29 August 2018

**Town and Country Planning Act 1990.
The Town and Country Planning (Development Management Procedure) (England) Order
2015**

RE: 6/2018/1516/COND – Submission of details pursuant to condition 1 (material samples), 4 (listed building details), 5 (roof survey) and 6 (listed fabric protection details) on planning permission 6/2017/2746/LB at Ramada Hatfield St Albans Road West Hatfield AL10 9RH.

DRAWING TITLE
Comet Hotel Lantern Detail

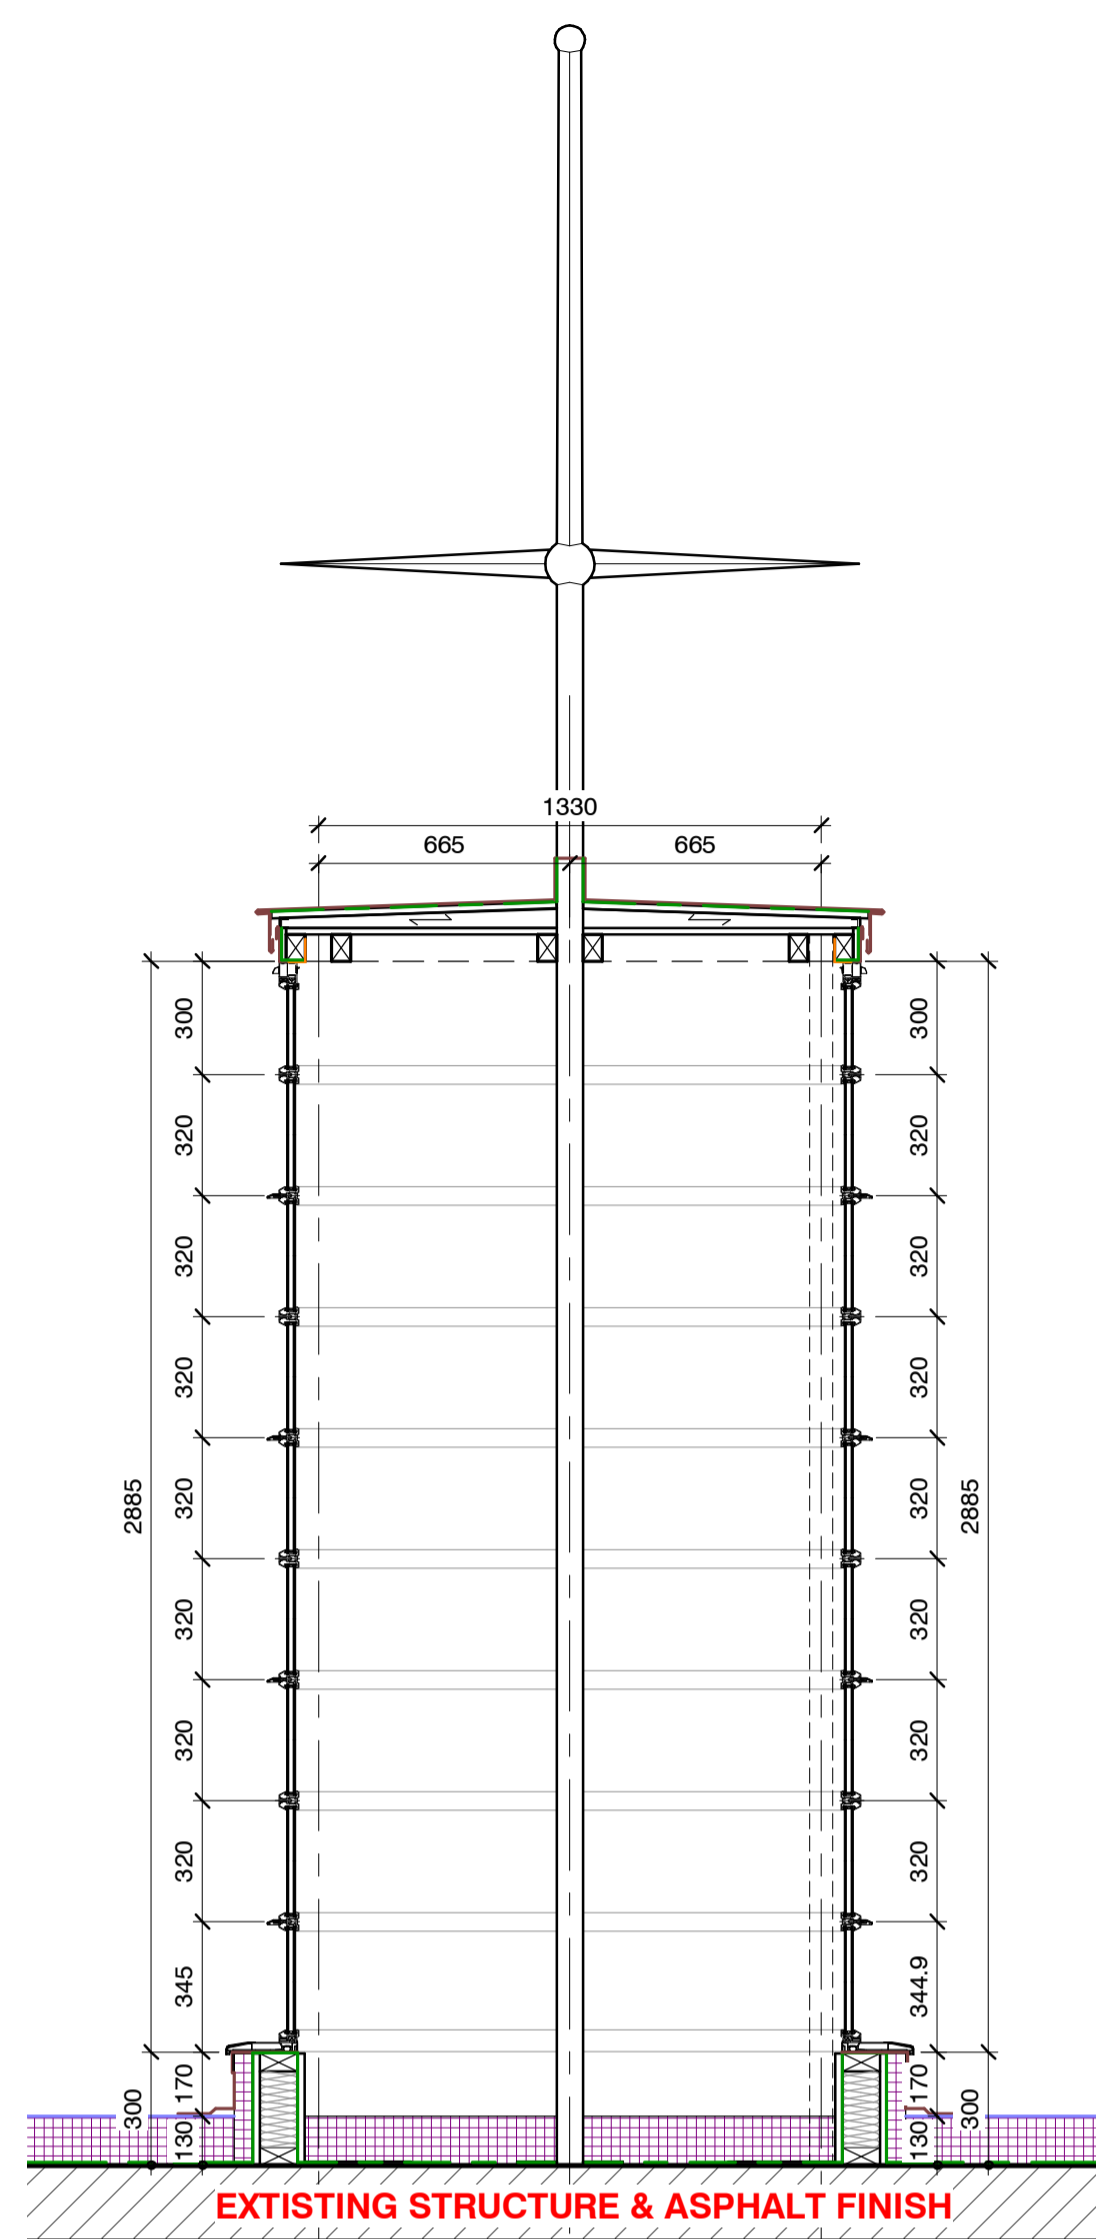
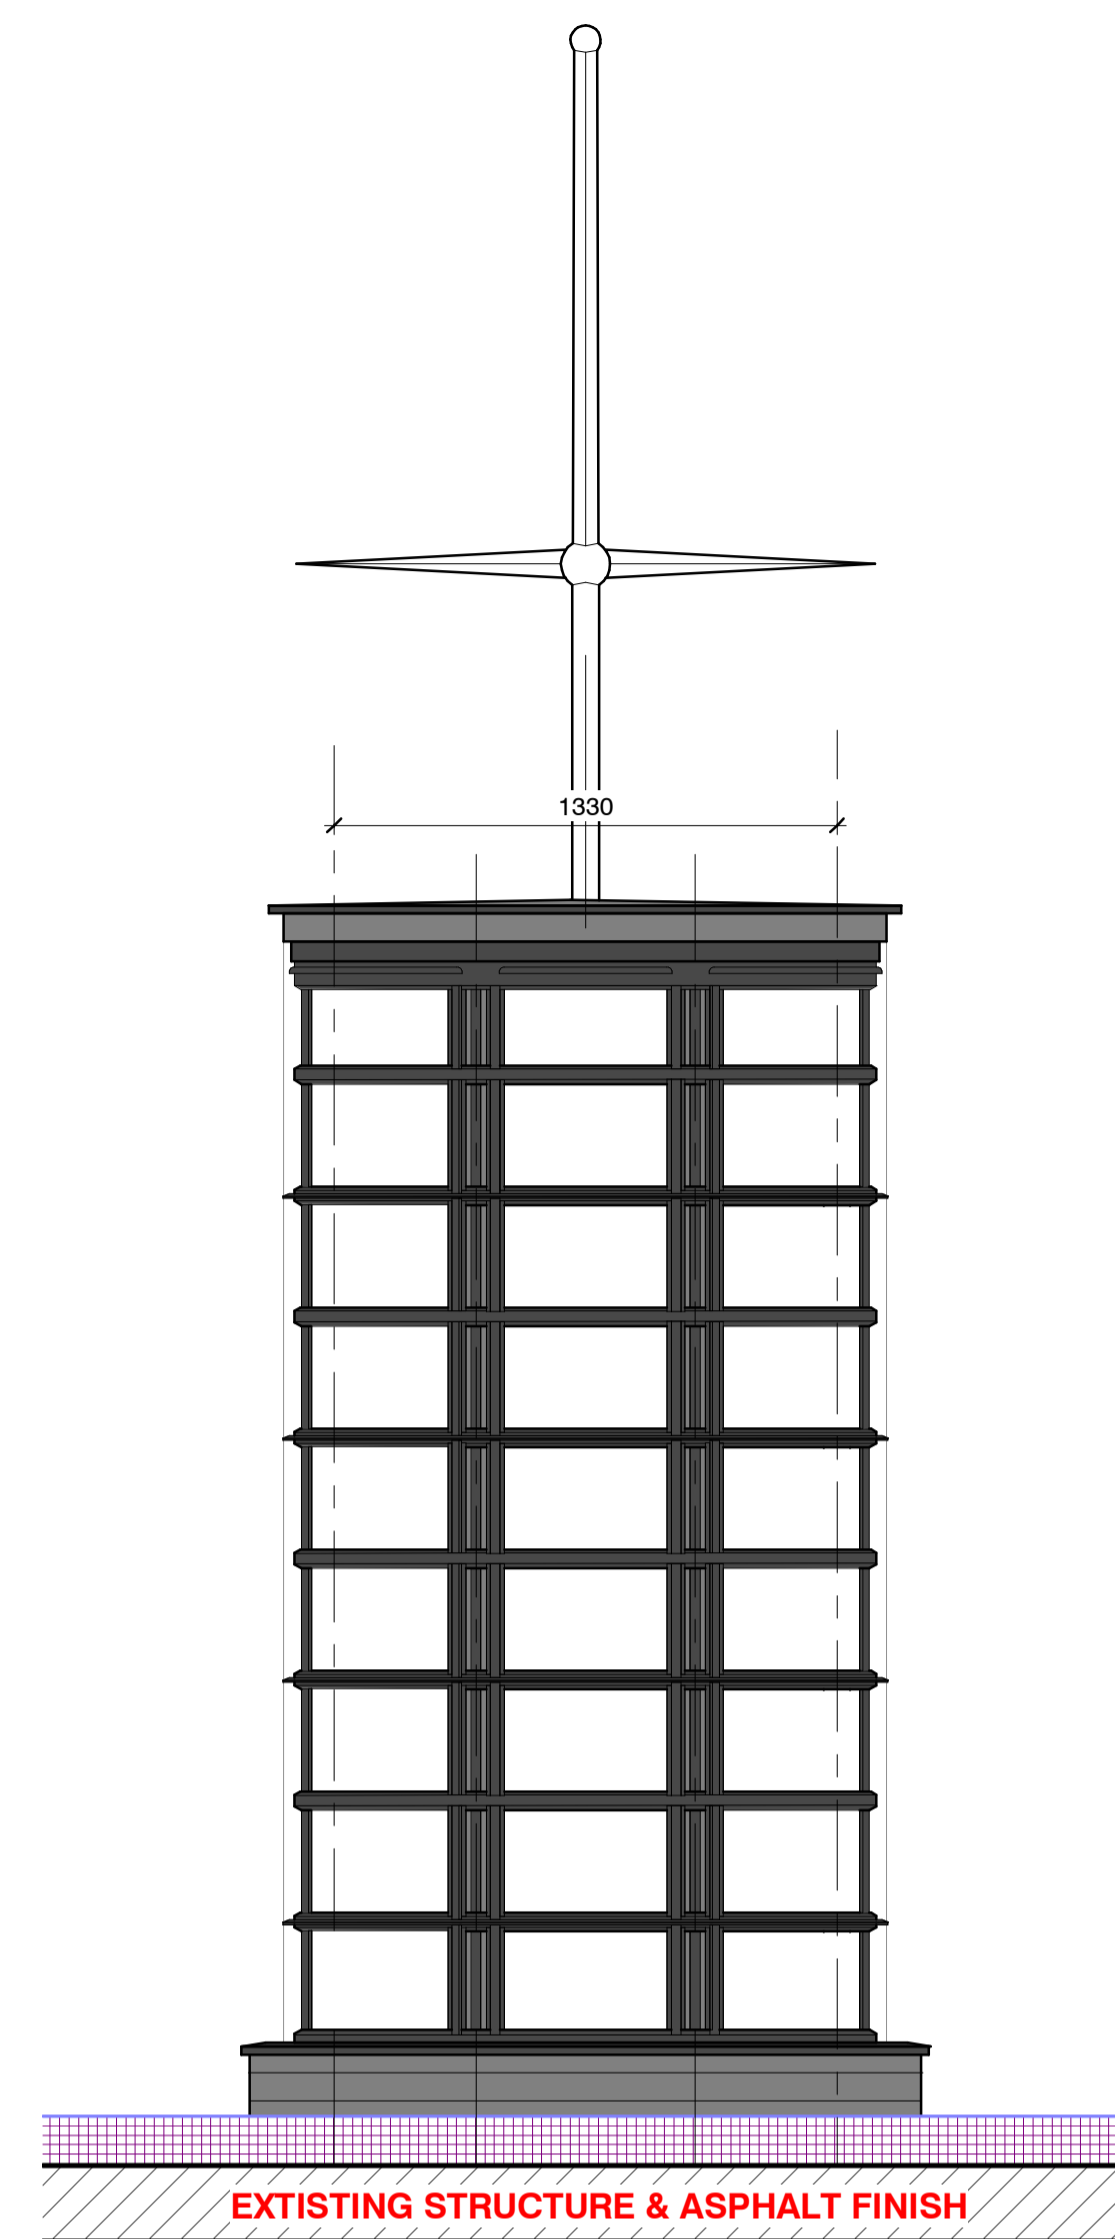
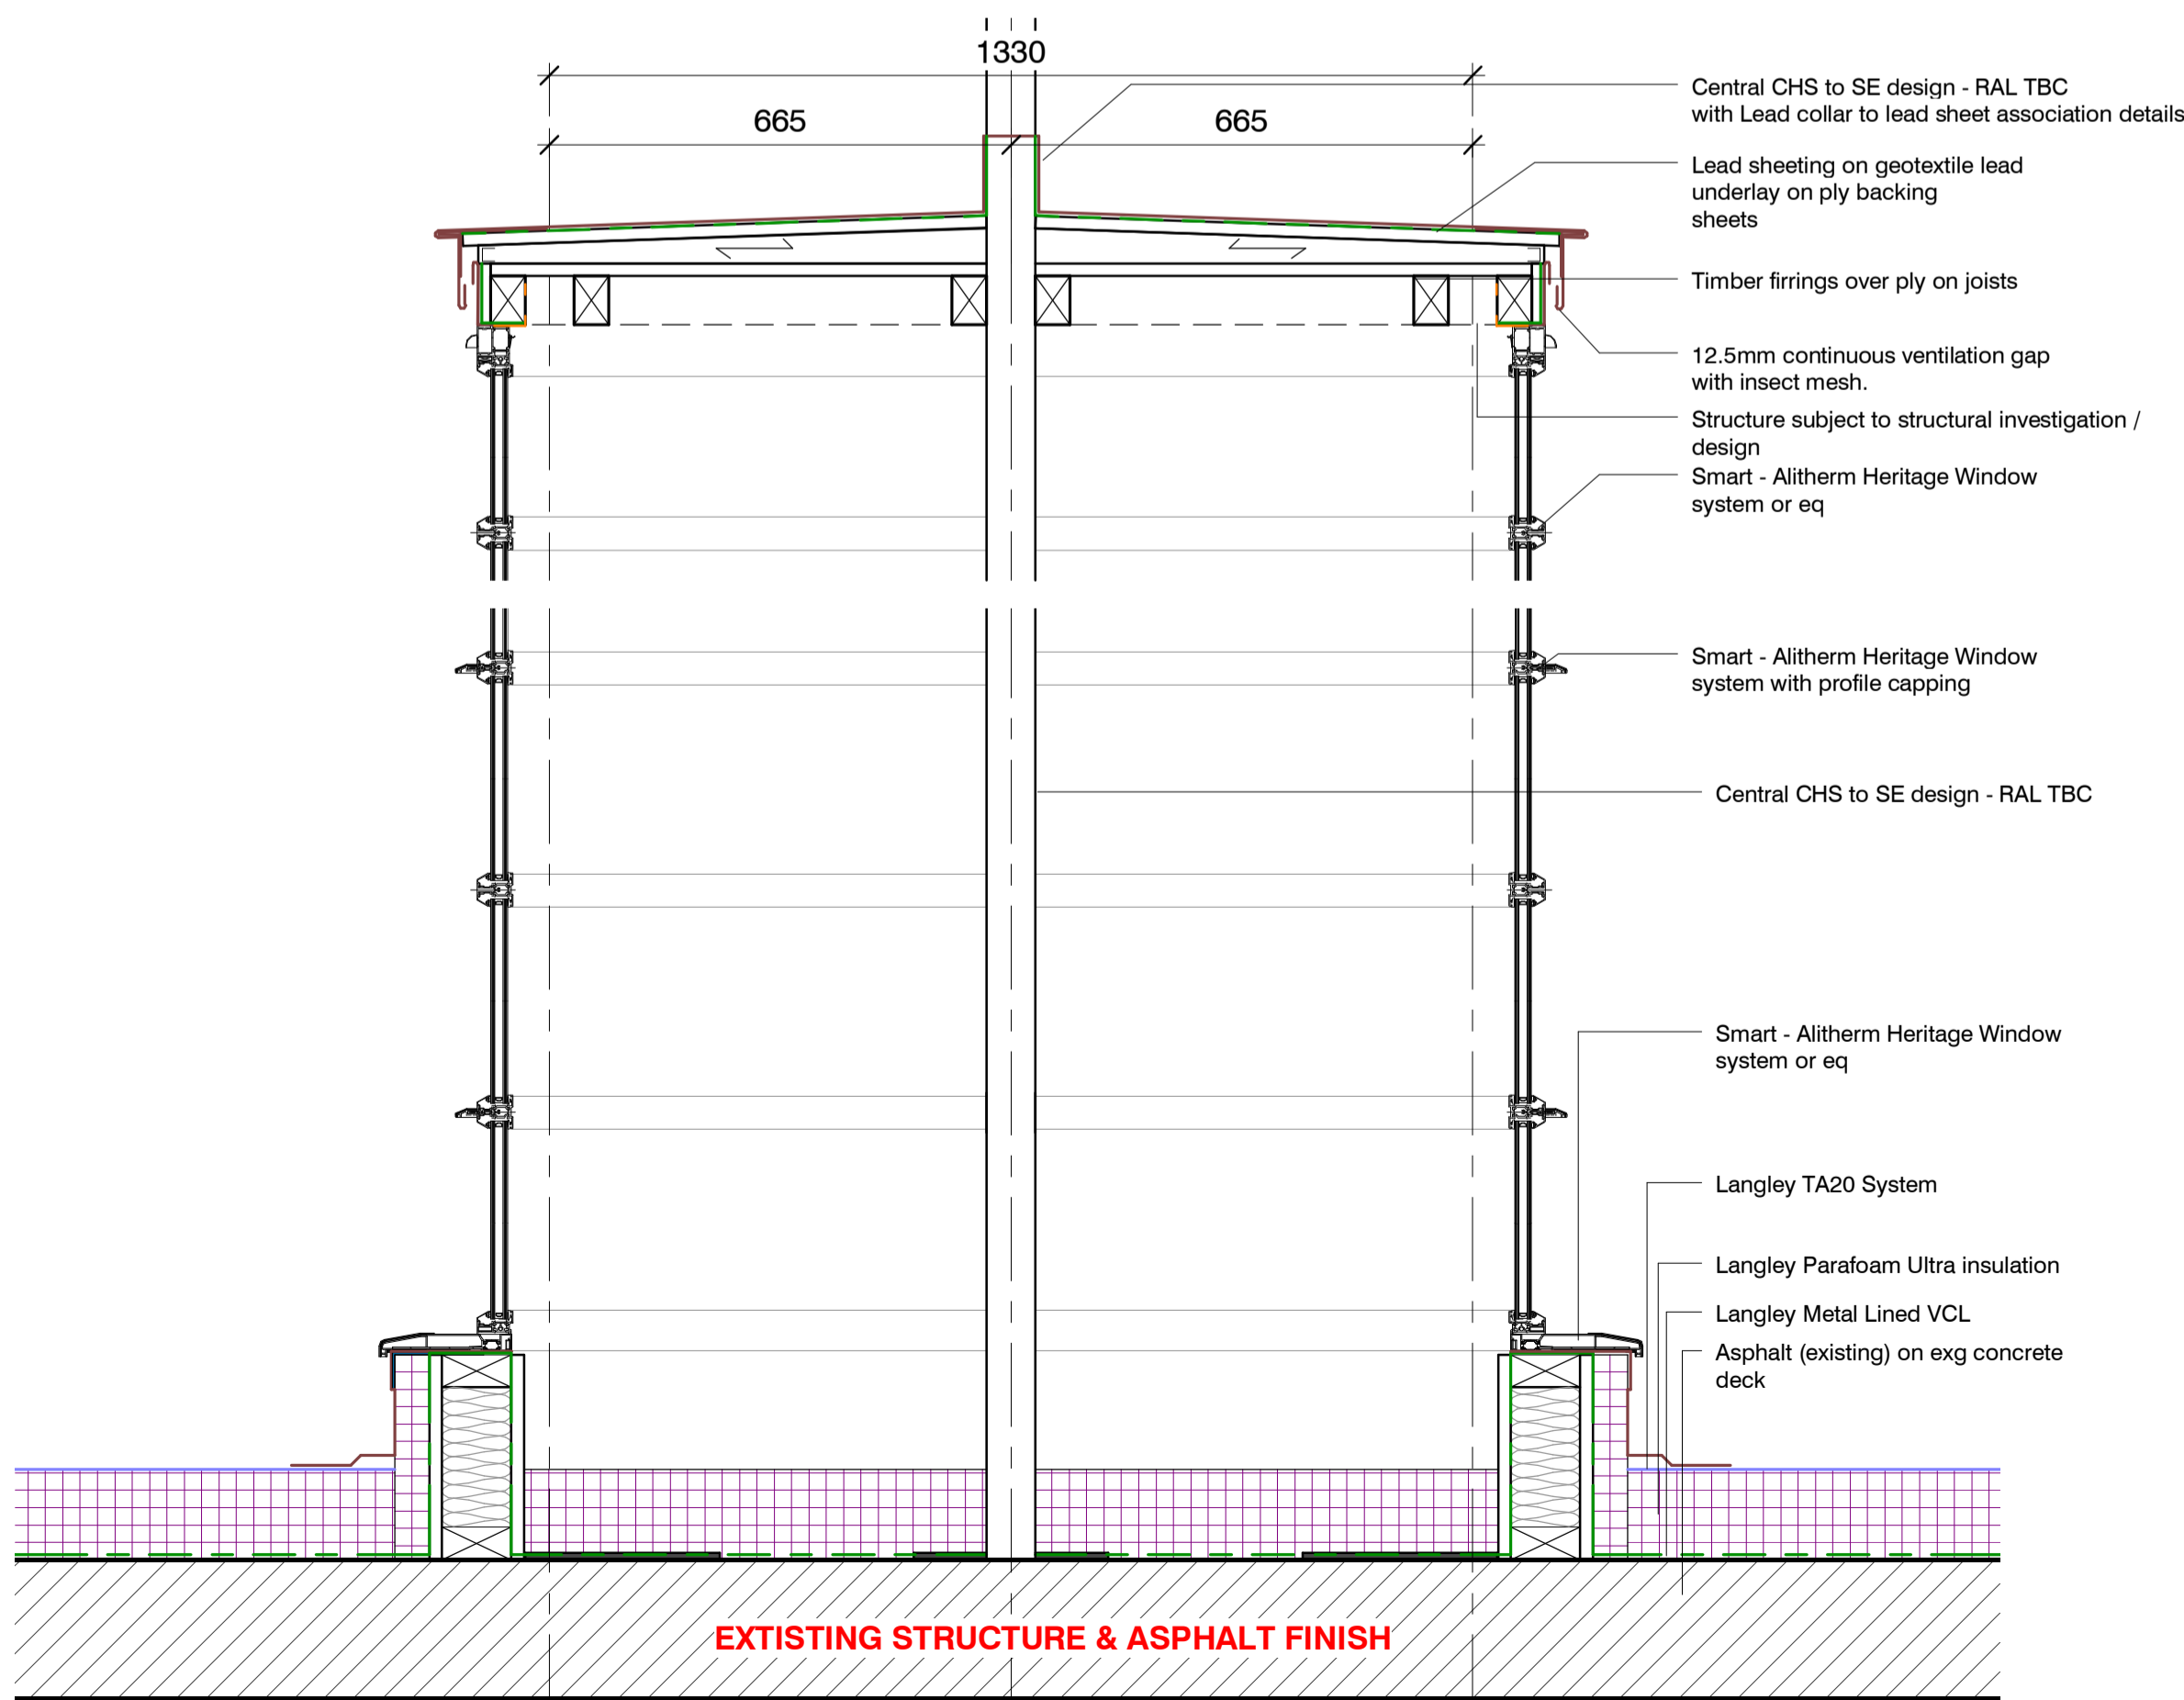
- (a) reinstatement of roof lantern (elevations at scale 1:20 and sections at 1:50);
- (b) retention of nibs to walls in the rear part of the listed building which were previously the chauffeur and garage quarters (floor plans at scale 1:50);

You will need to reapply for approval of samples and/or details for subsections (a), (d), (e) and (h) through to (k).
